Our ref: NA/2024/116840/02-L01
Your ref: EN070009
Date: 21 October 2024

**H2TEESSIDE PROJECT – ENVIRONMENT AGENCY COMMENTS ON DEADLINE
2 SUBMISSIONS
LAND EITHER SIDE OF THE RIVER TEES WITHIN THE BOROUGH OF
REDCAR AND CLEVELAND AND STOCKTON-ON-TEES ON TEESSIDE AND
THE BOROUGH OF HARTLEPOOL IN COUNTY DURHAM**

REP2-003 H2 Teesside Limited 2.4a - Integrated Works Plans

Work Plans Summary Key Plan

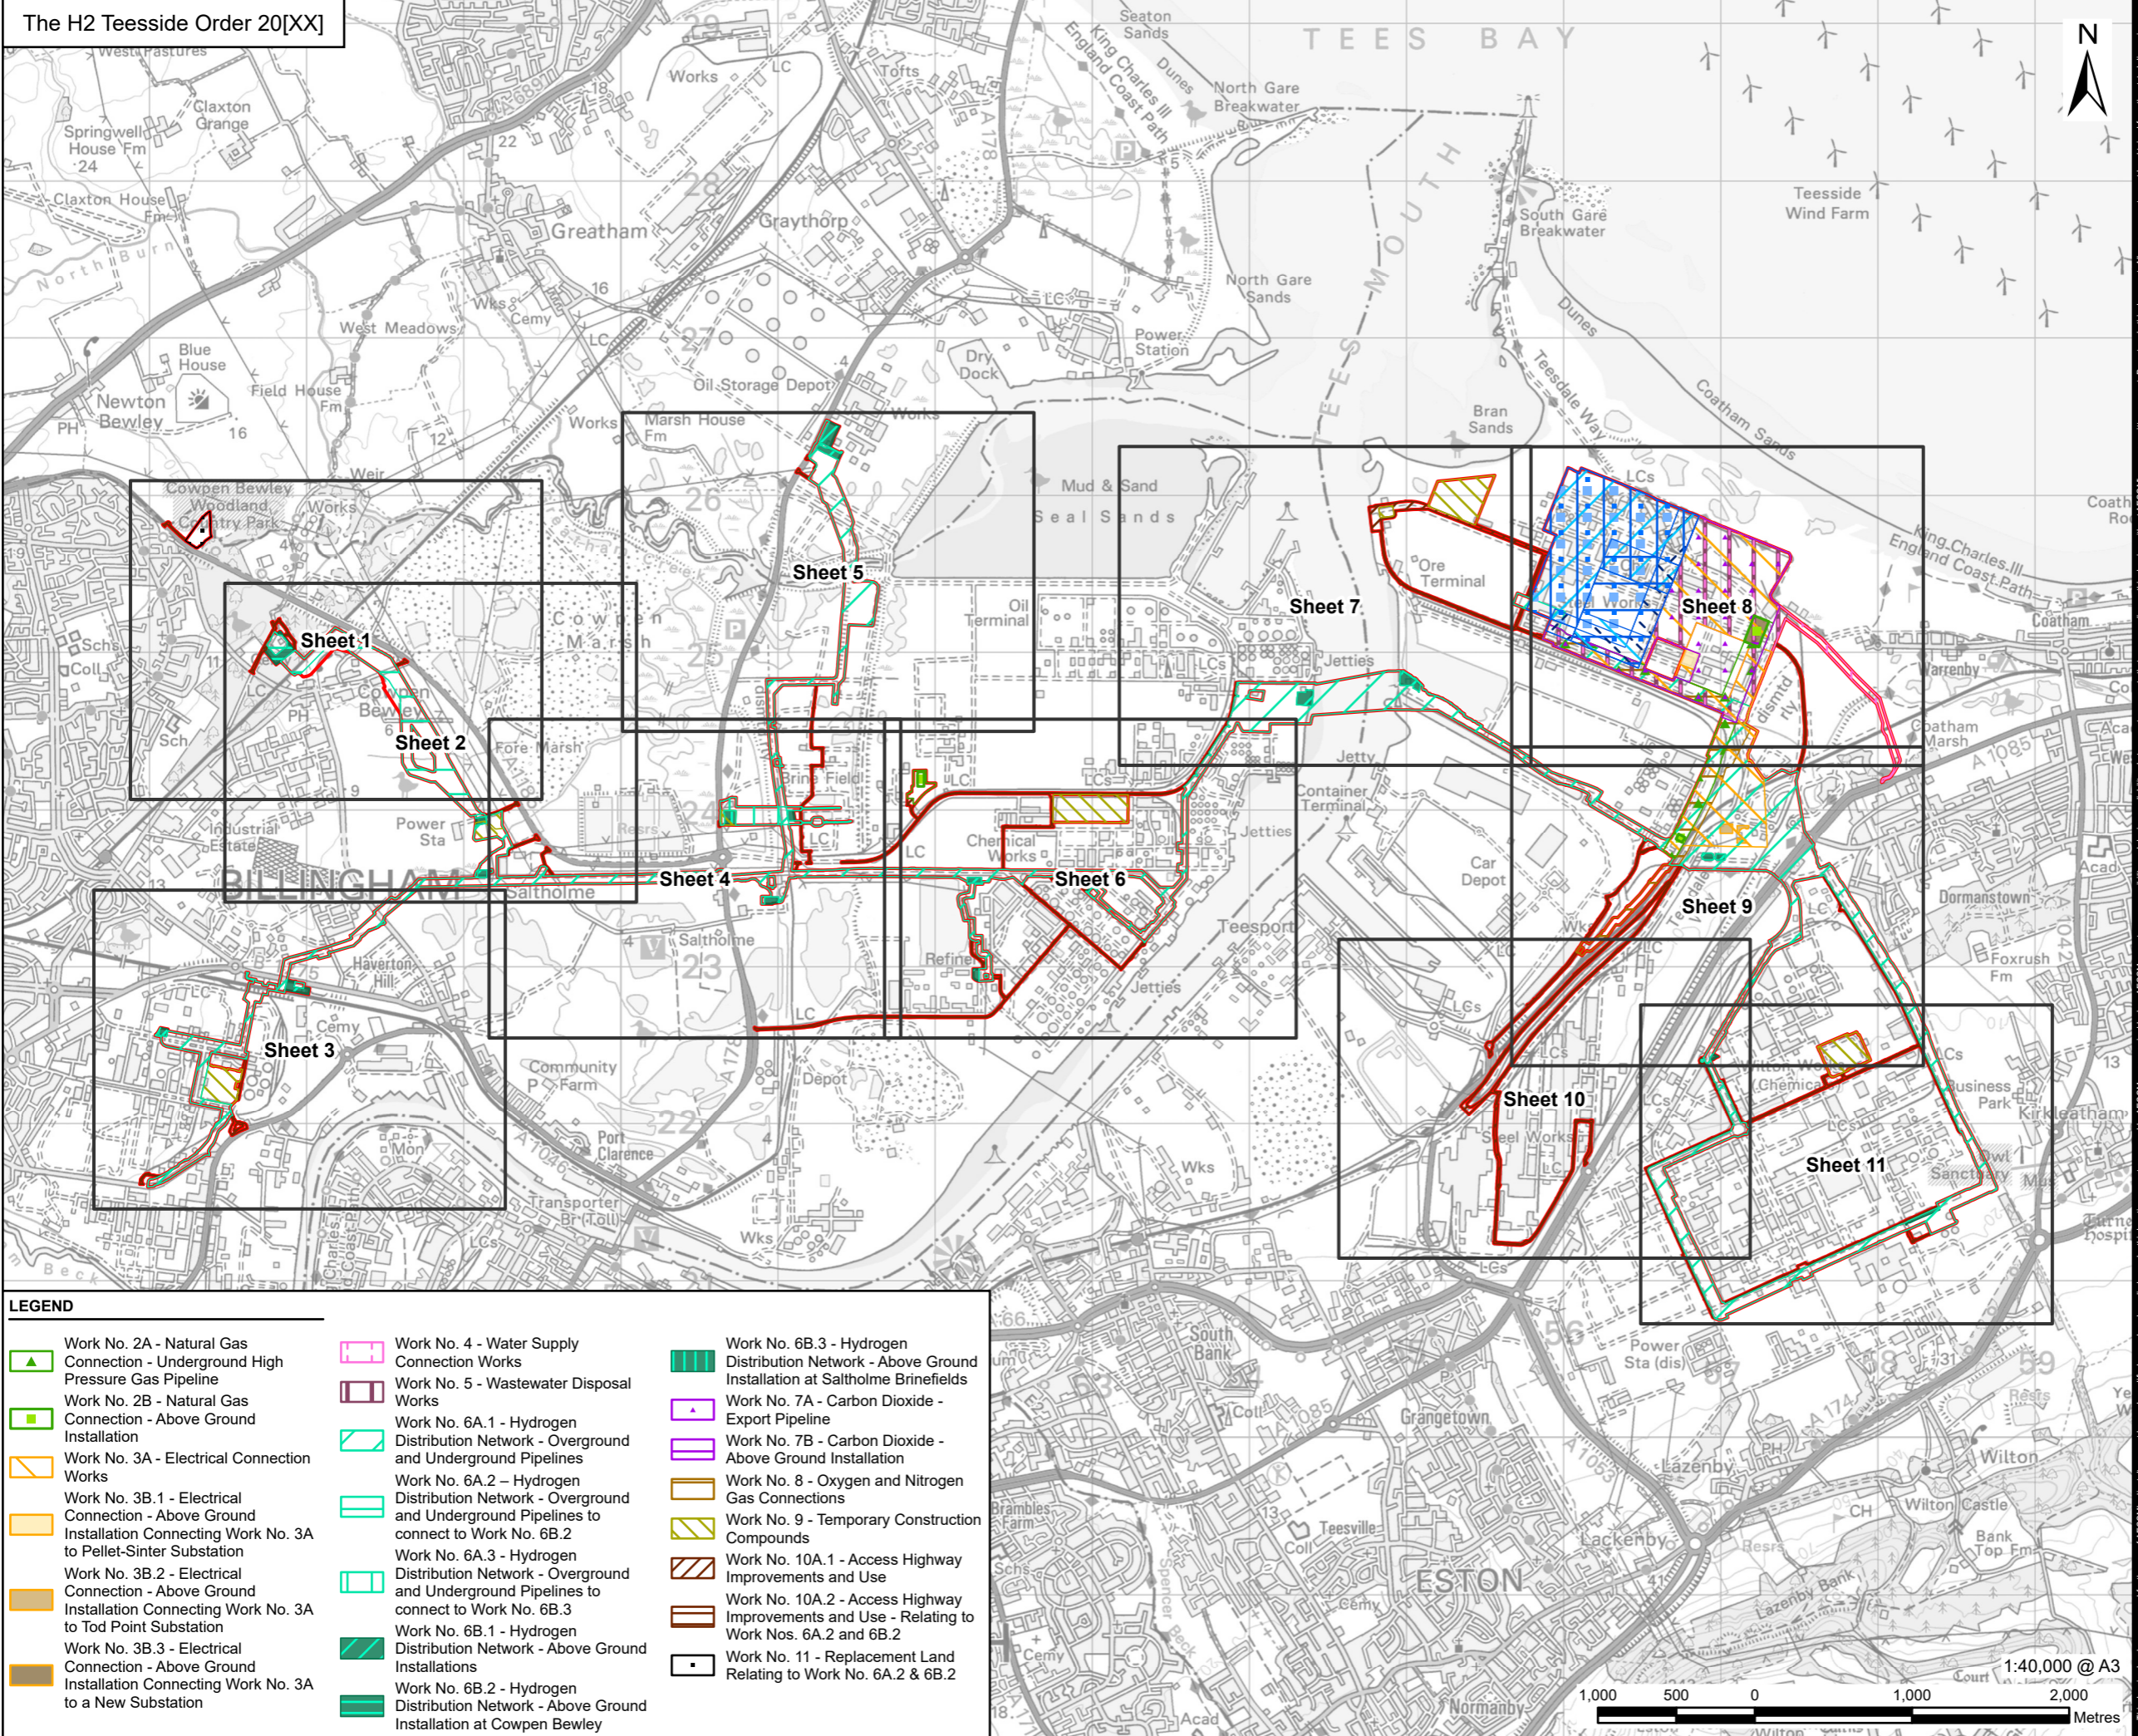
This document helps to provide more clarity on the land uses associated with the works on one consolidated map. The key still uses “*Work No. 6A.1 - Hydrogen Distribution Network - Overground and Underground Pipelines*”, meaning it is not clear at this stage which of the two will be used in these areas. There will be different flood risks associated with underground pipeline corridors and overground pipelines in Flood Zone 3. This should be confirmed by the applicant. The plans also continue to identify areas of temporary storage that will be in flood zones. As previously discussed, this will require a permit/disapplication and additional mitigation will be required to ensure no increase in risk.

We previously flagged for information to the applicant in our Relevant Representations response, dated 1 July 2024, of a site that is currently being investigated under Part 2A of the Environmental Protection Act 1990. Reviewing this, we wish to make the applicant aware that our response included an incorrect grid reference. The site was previously known as Seal Sands Chemicals Company (SSC) and the correct grid reference is NZ 53843 24721. For information, we can confirm that this area adjacent to Work No. 6A.1 - Hydrogen Distribution Network - Overground and Underground Pipelines, includes a Part 2A inspection area.

APPENDIX 1: MAP OF INDICIATIVE LOCATIONS EXCEEDING ORDER WIDTH

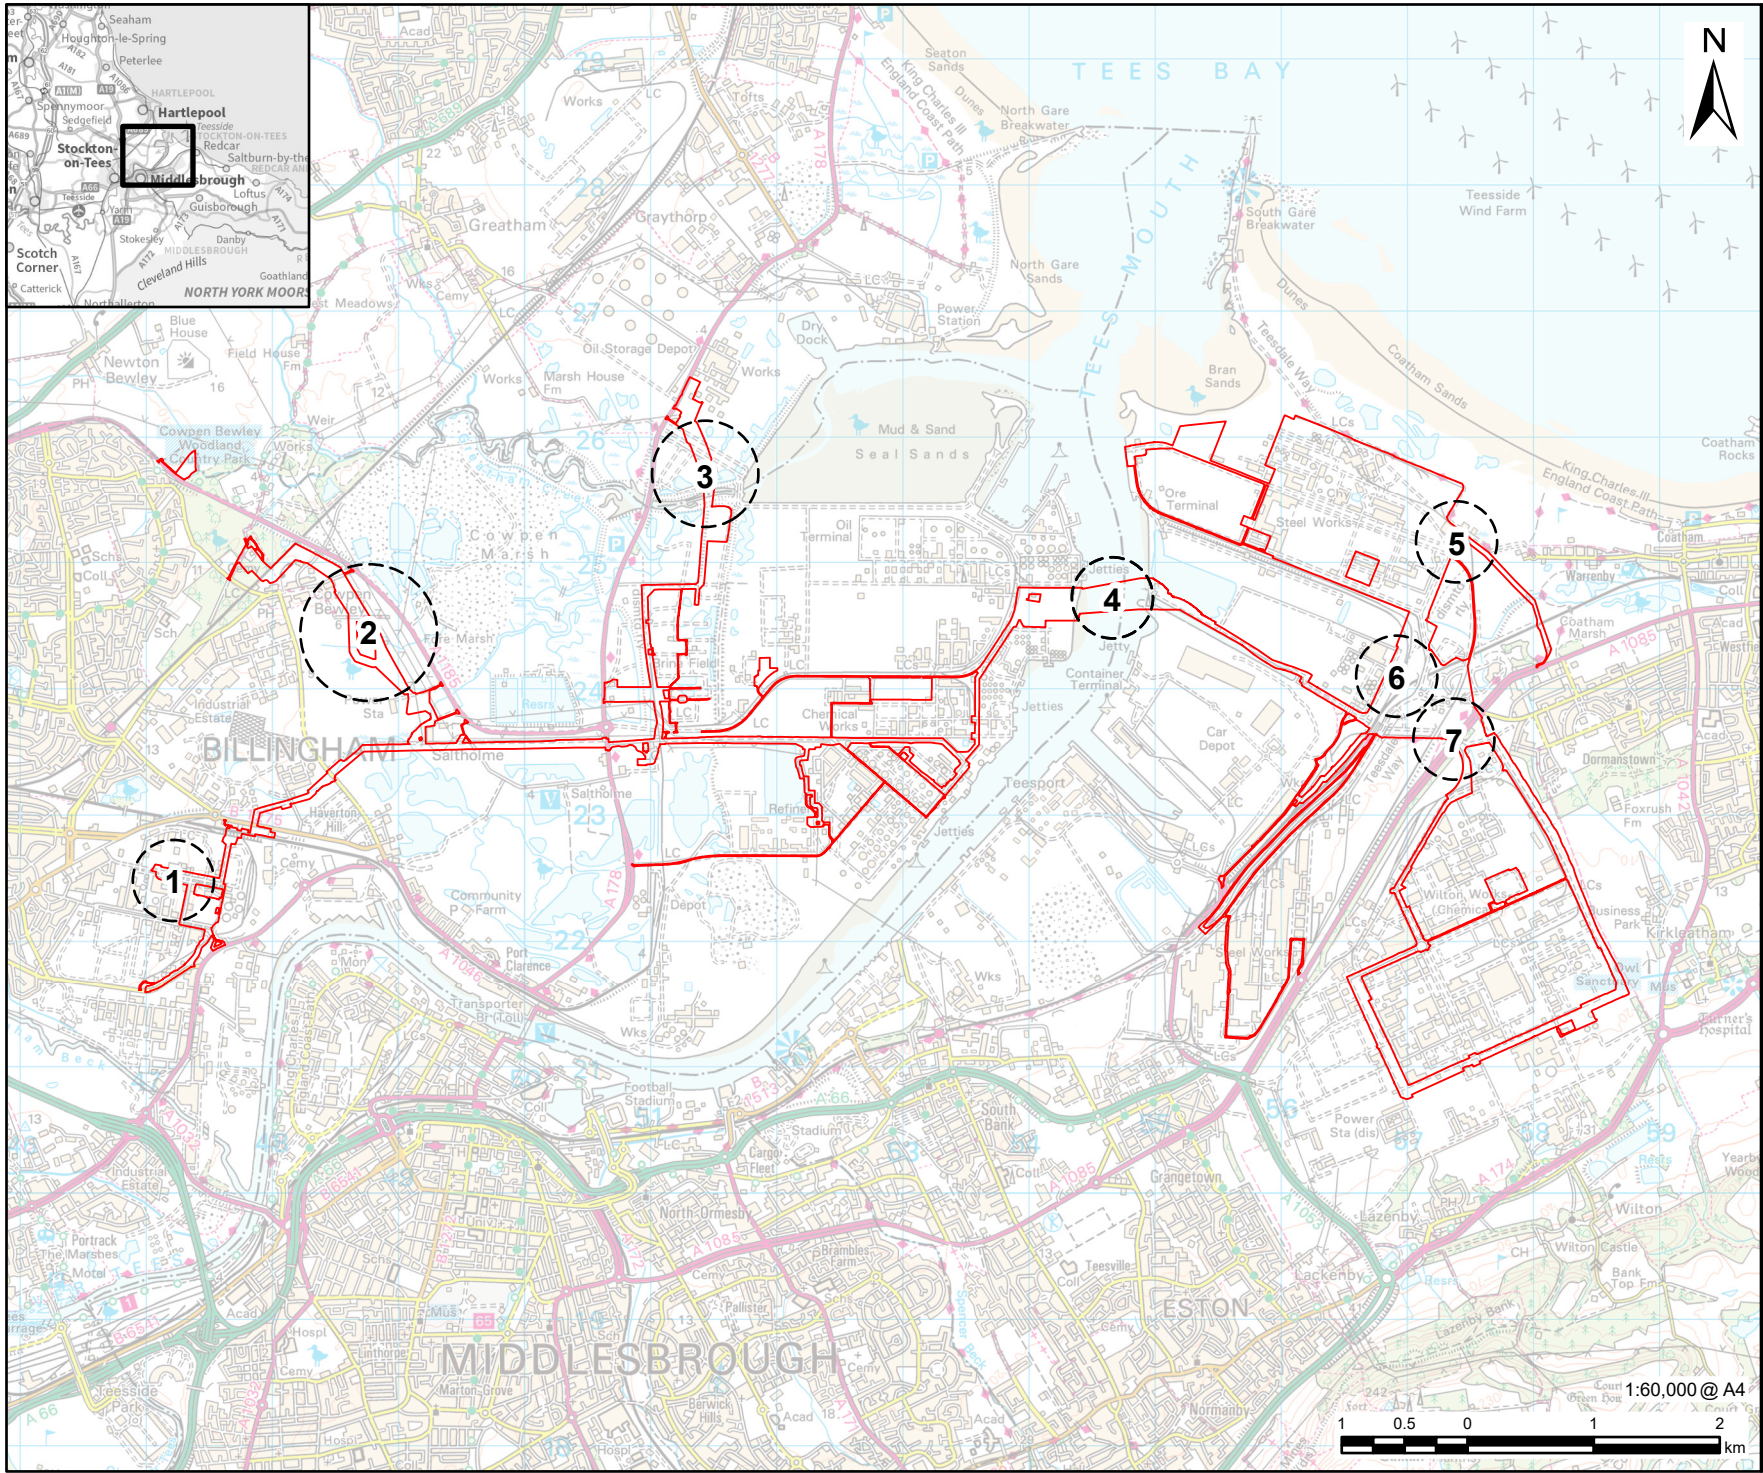
From a flood risk perspective, we support the use of Horizontal Directional Drilling (HDD) methods, as it will minimise surface disruption as well as ensure that ground levels remain unchanged throughout the process.

However, an increase in corridor width could have potential flood risk implications. We understand the need for a wider corridor width whilst GI has not been conducted, as it allows for wider flexibility for the location of the drilling path, however, if located near a flood defence, a narrower corridor width would be preferred as it can be more closely managed to ensure no damage or destabilisation to any flood defense infrastructure.

Final drill routes and methods should be included in the Construction Environment Management Plan or other relevant document and shared with the Environment Agency for approval.
